From: Ross Leal
Sent: 24 March 2015 15:23
To: [REDACTED]
Subject: AW/360/14/HH - 91 The Fairway, Aldwick
Attachments: 201503241520.pdf

From: Ross Leal
Sent: 23 February 2015 13:29
To: [REDACTED]
Subject: AW/360/14/HH - 91 the Fairway, Aldwick
Attachments: IMG_20150205_105217.jpg; IMG_20150205_105314.jpg

As discussed, the proposed side extension will be in close proximity to an adjoining hedgerow which presently provides screening to the adjoining dwelling. Please see attached photos. Your drawing 9A (Dec 2014) appears to indicate a boundary line, but not the extent (width) of the hedge line and proximity to the proposed extension. The key issues are the proximity and the hedgerow and also the root system to the proposed extension and of course its foundations, which will extend beyond the side wall of the proposed extension.

DEC 2014
DEG 9A

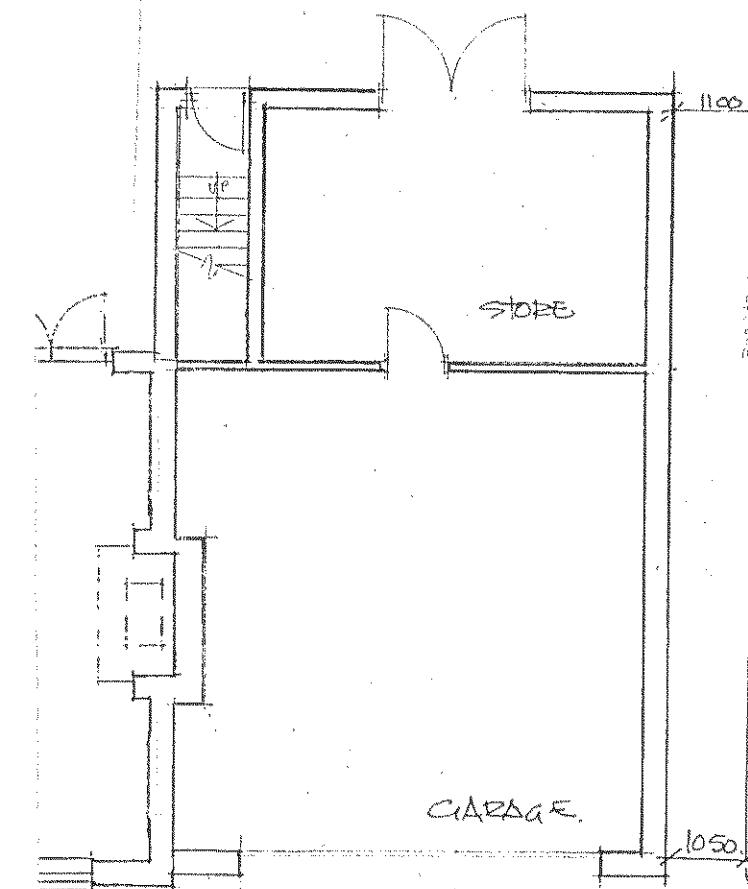
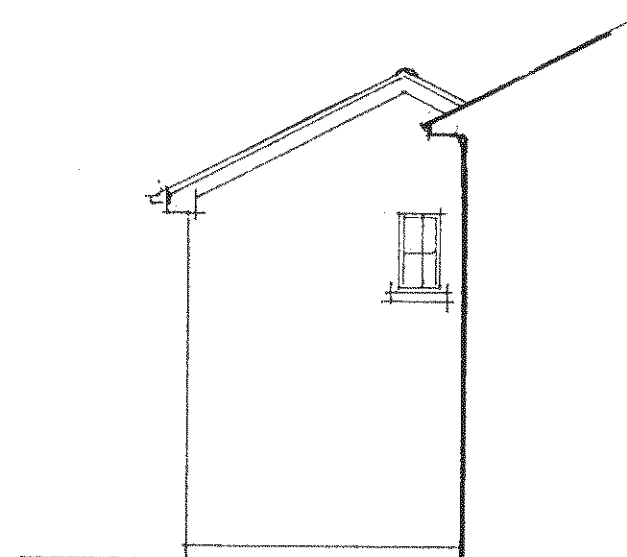
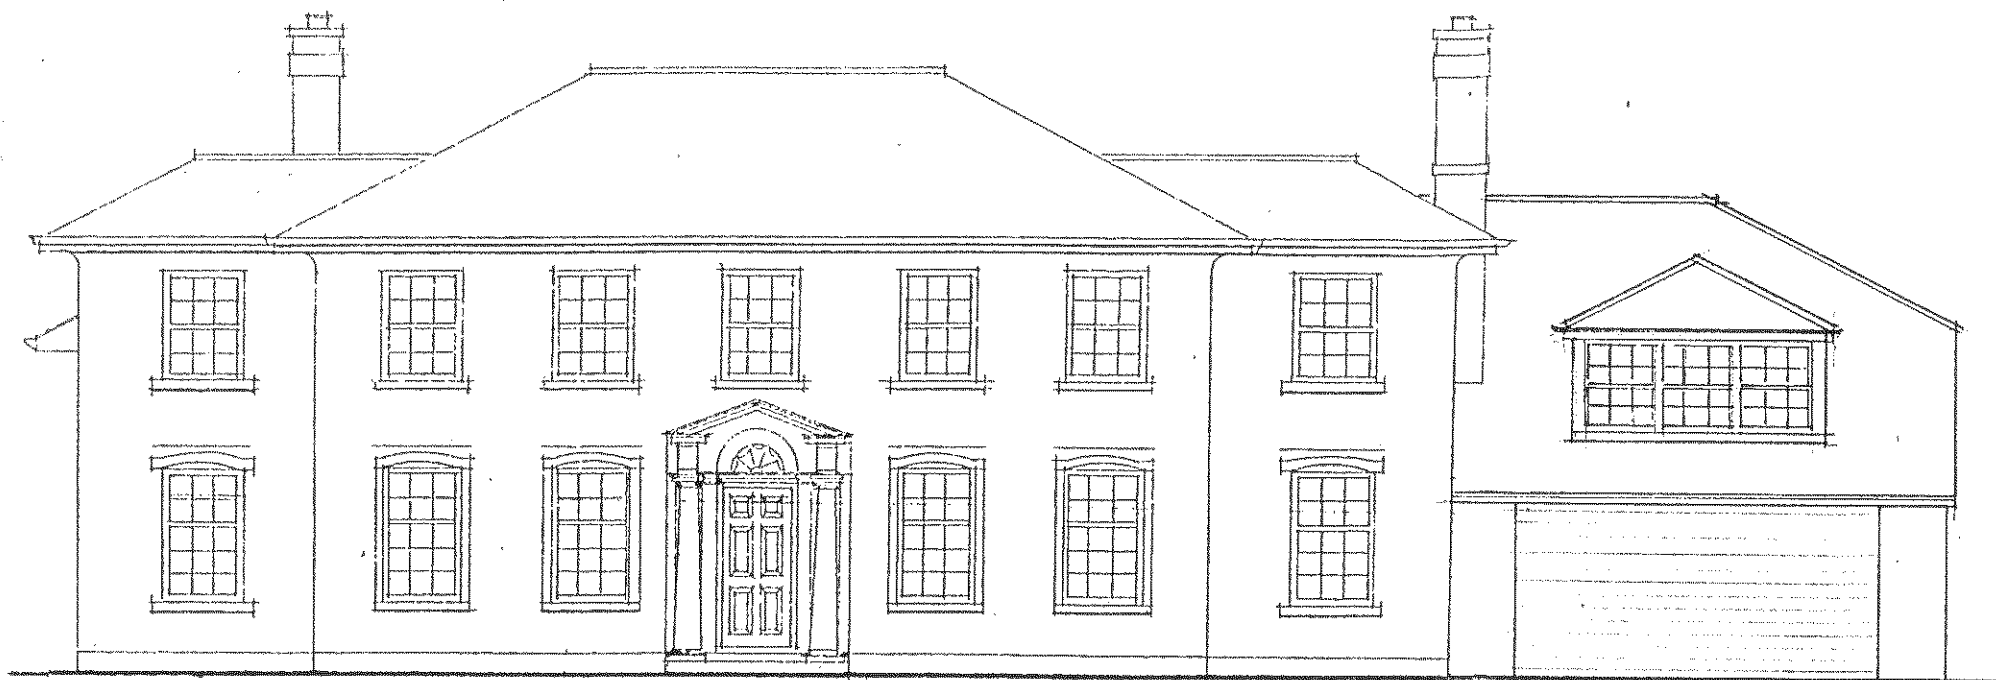
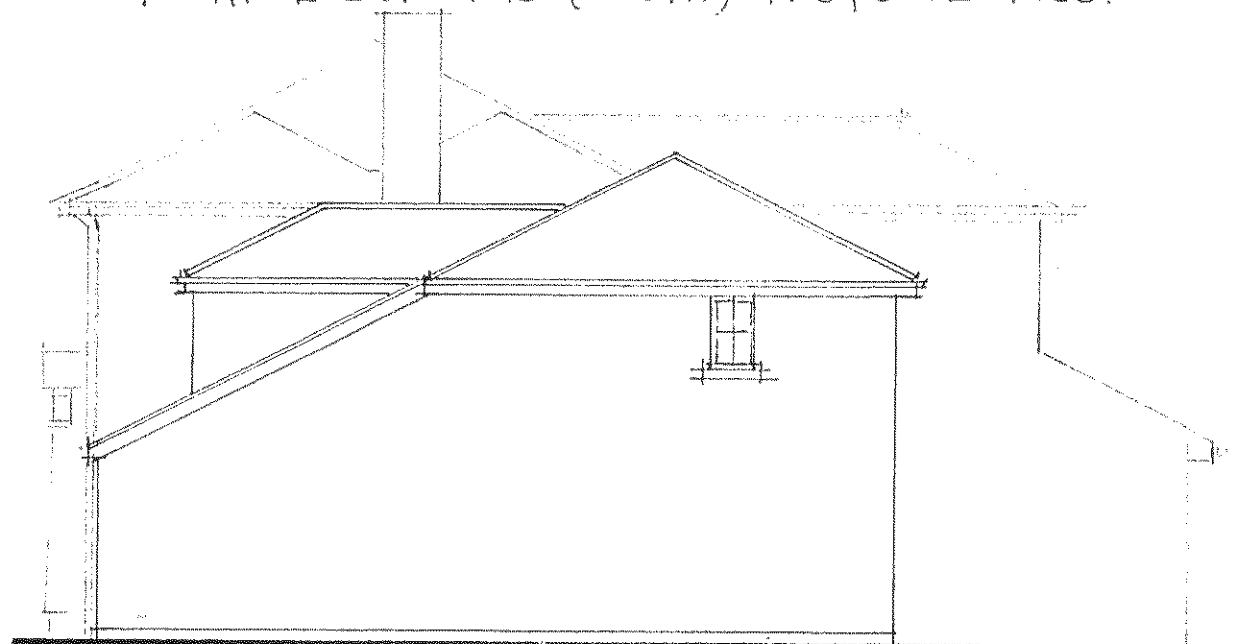
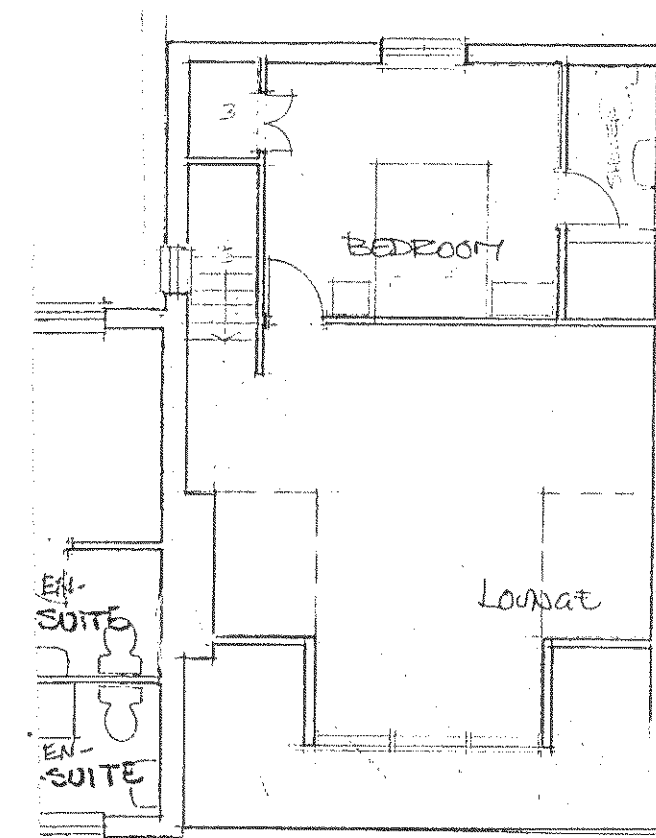
Please provide an accurate measured survey which indicates the precise location and extent of the hedgerow, at least in the area adjoining the proposed extension. This is necessary in order to assess potential impact of the hedgerow and amenity/privacy.
